Rezoning Transportation Analysis

Petition Number: 2022-139

| Date | Description |
|---------|--------------------|
| 2-22-23 | Second Review (TM) |

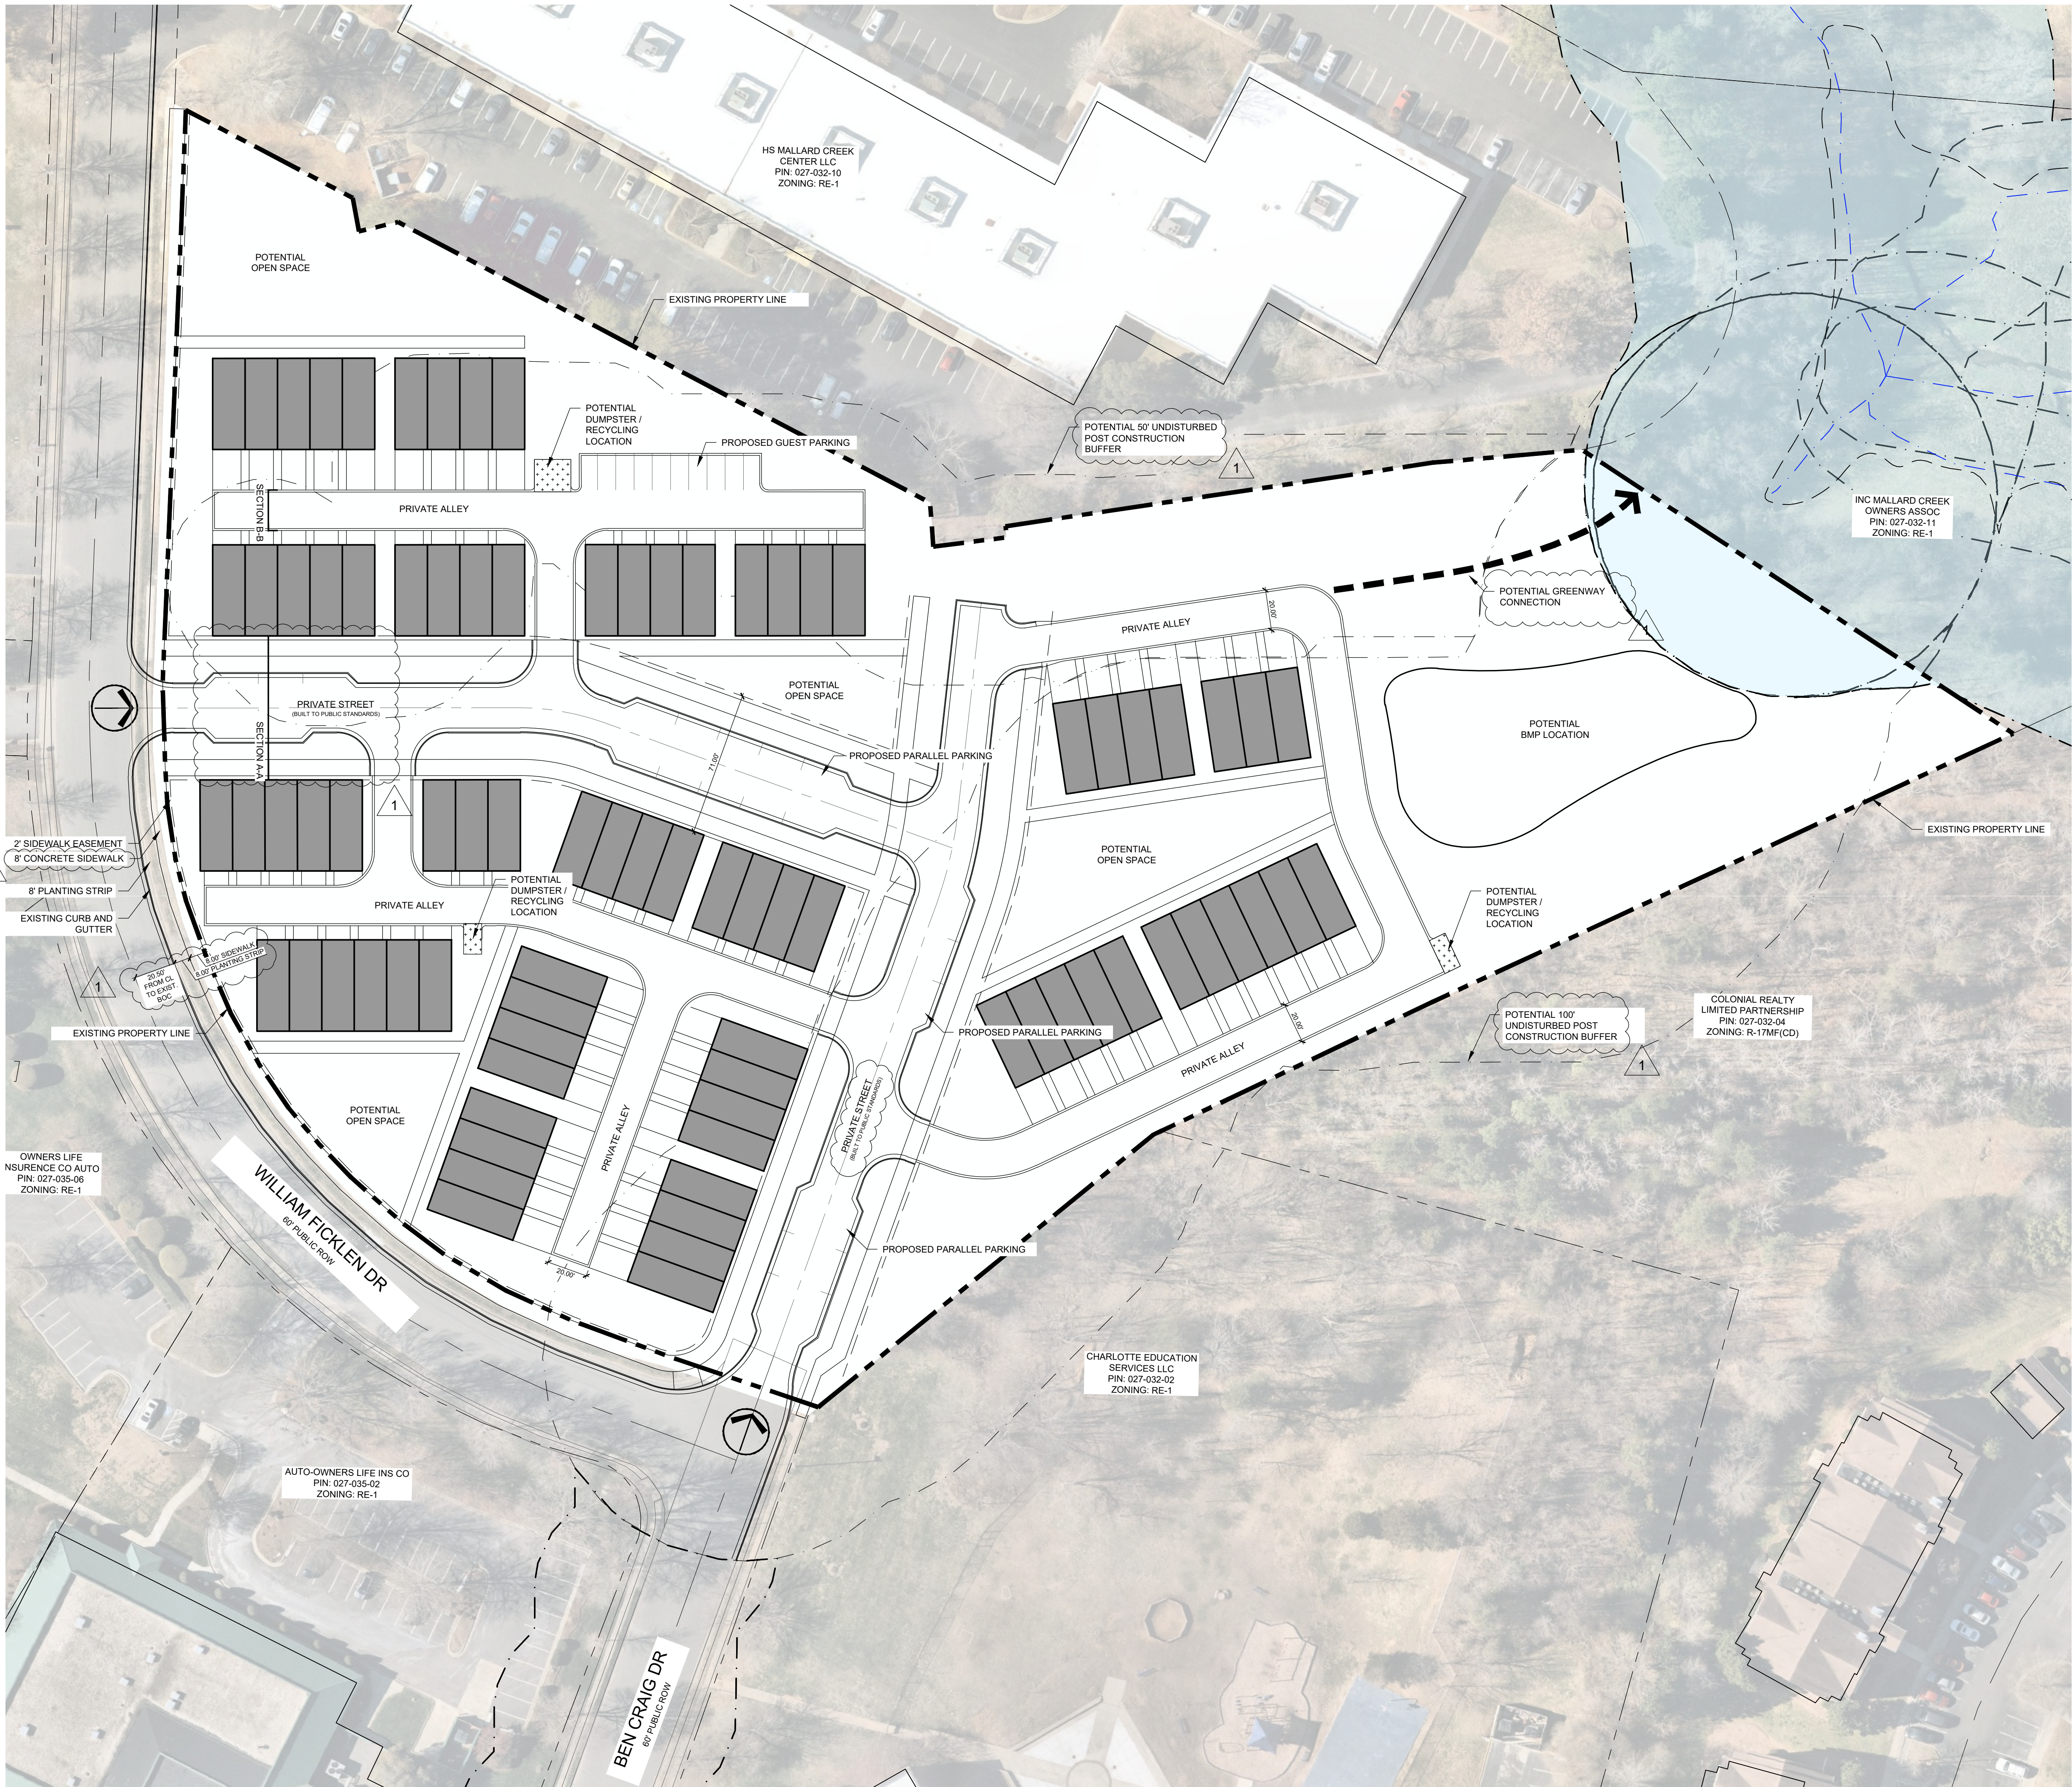
7. Revise conditional note(s) to commit to meeting intersection sight distance requirements. Site entrance locations will be required to meet all ISD requirements.
8. Revise site plan to show proper separation between the proposed on-street parking and the intersection. A minimum of 20-feet is required from the curb return to the parking stall.
